Ribble Valley Borough Council
Housing & Development Control

Your ref: 3/2023/0452
Our ref: D3.2023.0452
Date: 10th July 2023

Application no: **3/2023/0452**

Proposal: **Proposed construction of single storey pavilion restaurant. Change of use of grazing land to hotel grounds and to facilitate new vehicular access, parking and landscaping.**

Drawing title
 TREE REMOVAL PLAN

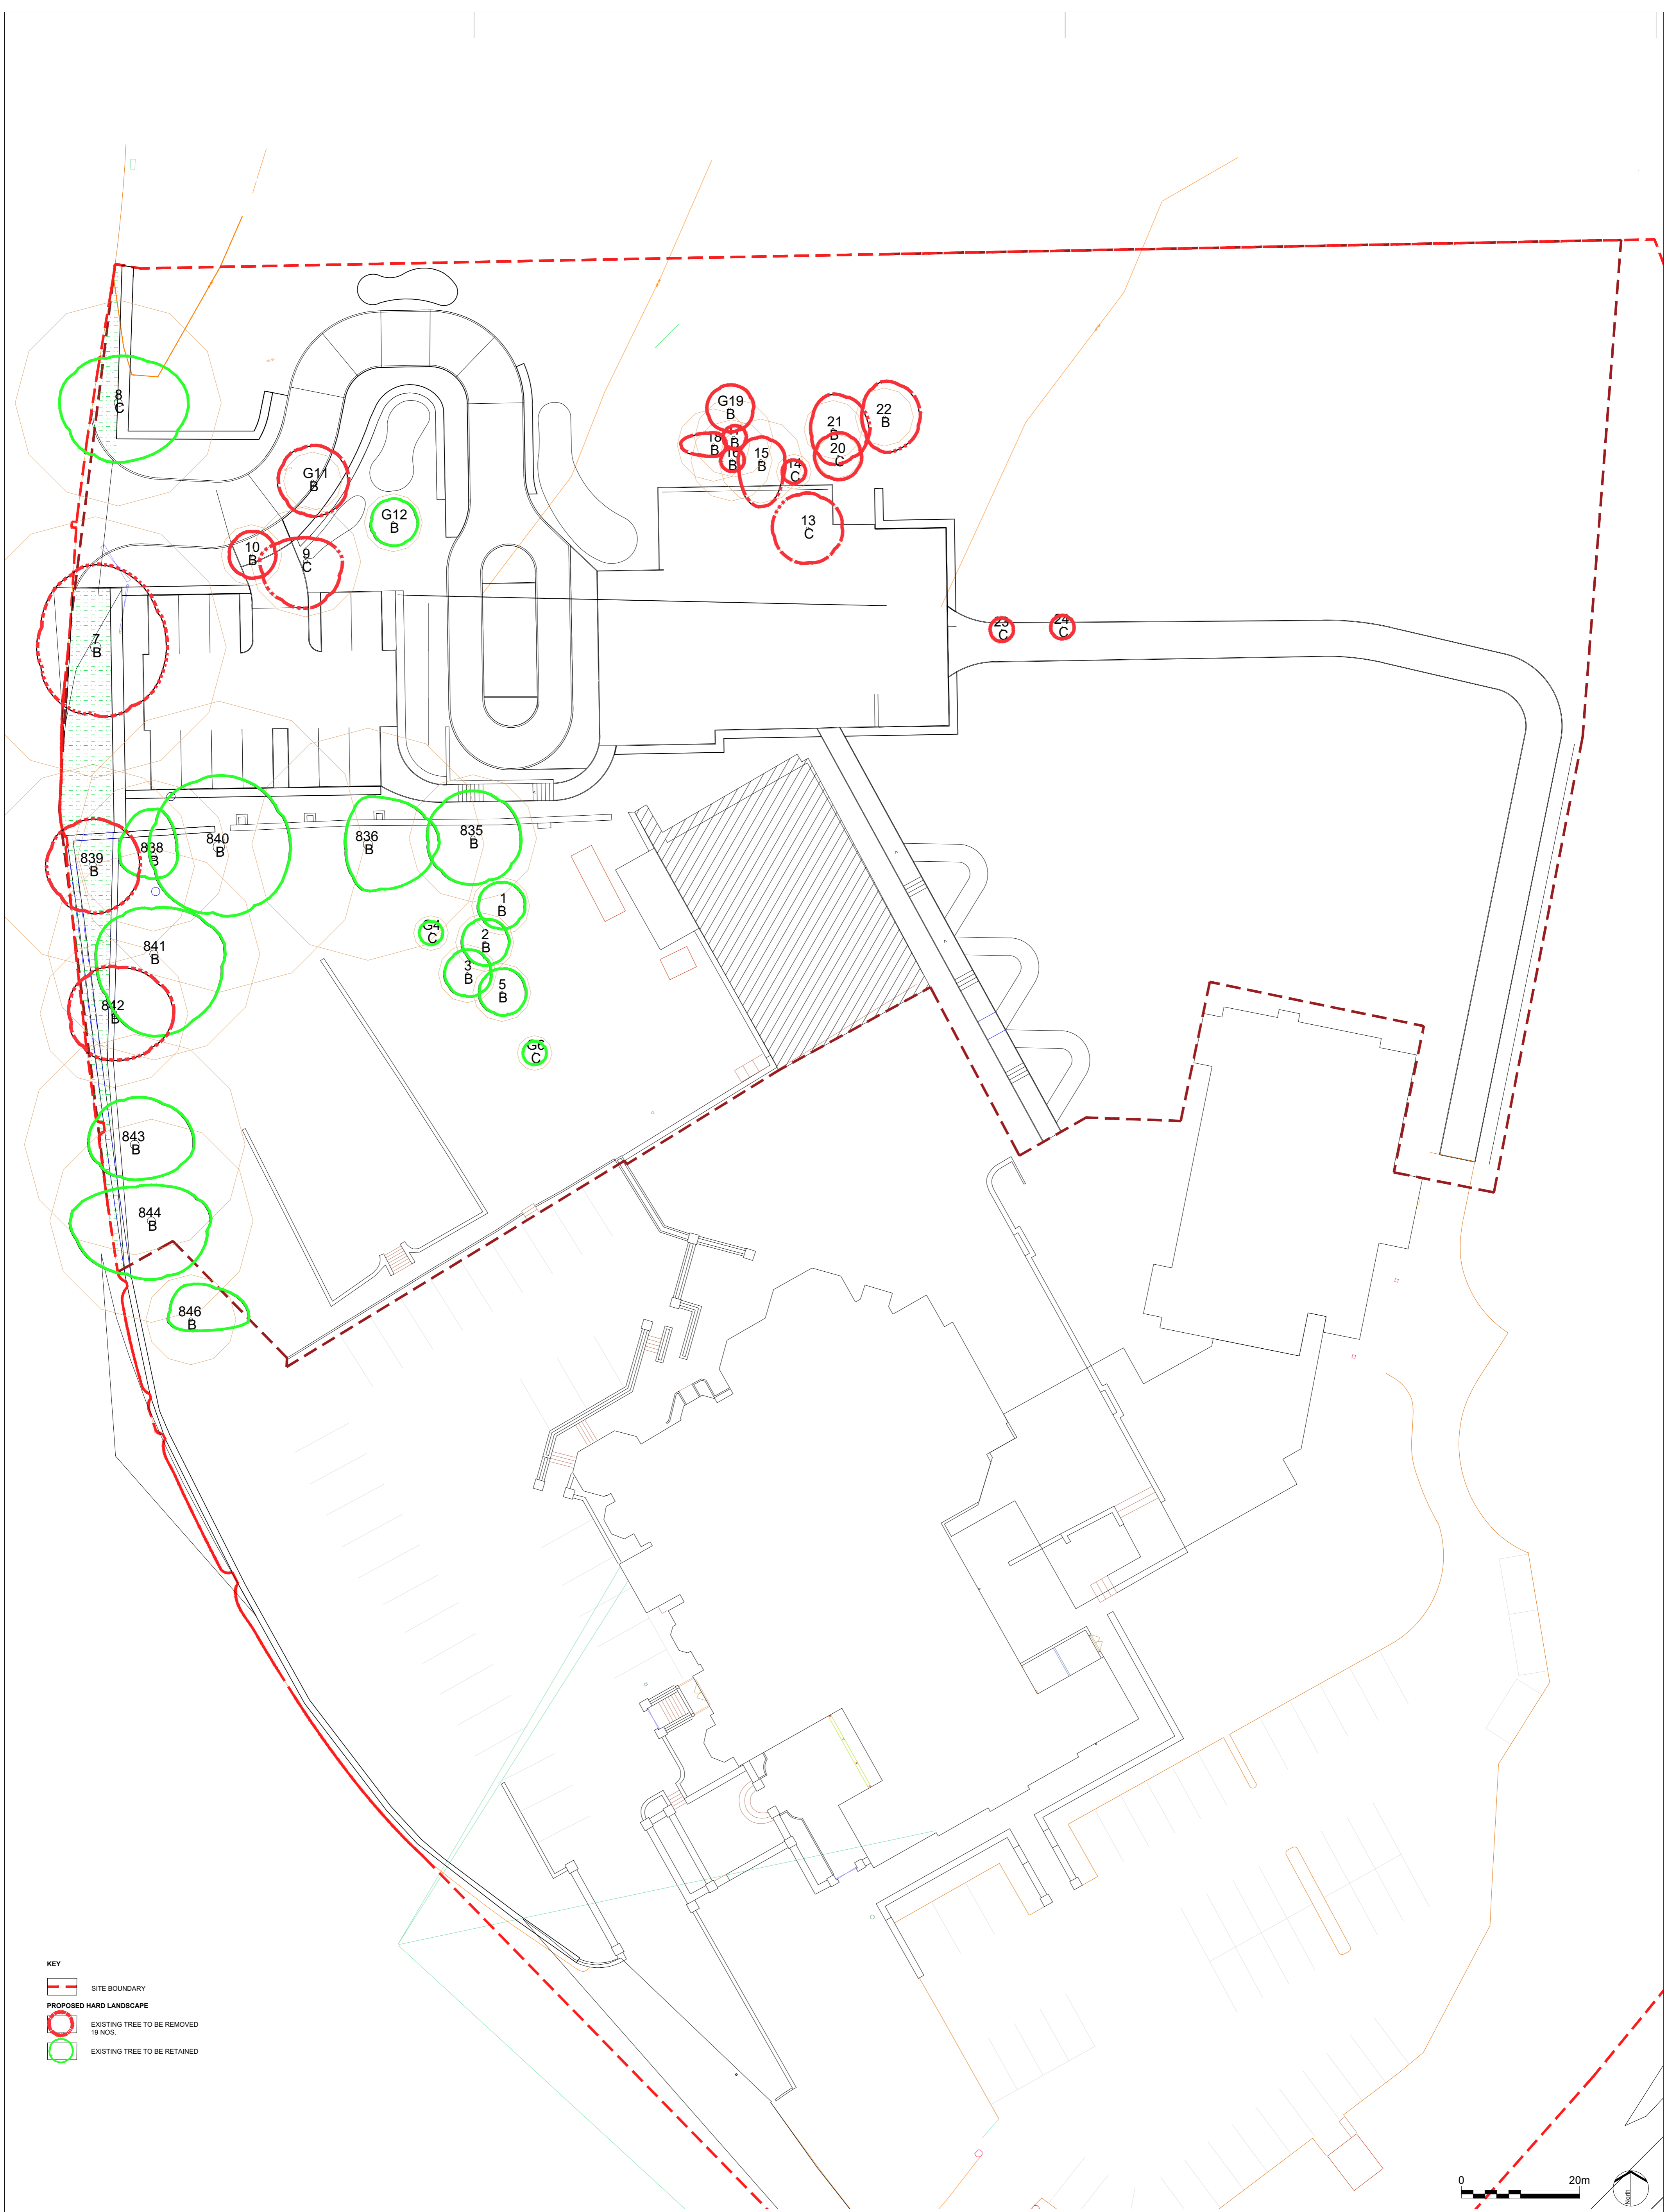
However, while the LHA can accept the visibility splay to the north of the site access, the LHA require the two trees closest to the site access to the south to be removed. This is to ensure that there are no obstructions to the site's visibility splays, with these trees obstructing the view along Northcote Road. Therefore, the LHA require these trees to be removed as part of any works. As a result, these trees should be shown on an amended plan for Exterior Architecture drawing number 2261-EXA-XX-XX-DR-L-00150 Rev P02 titled "Tree Removal Plan."
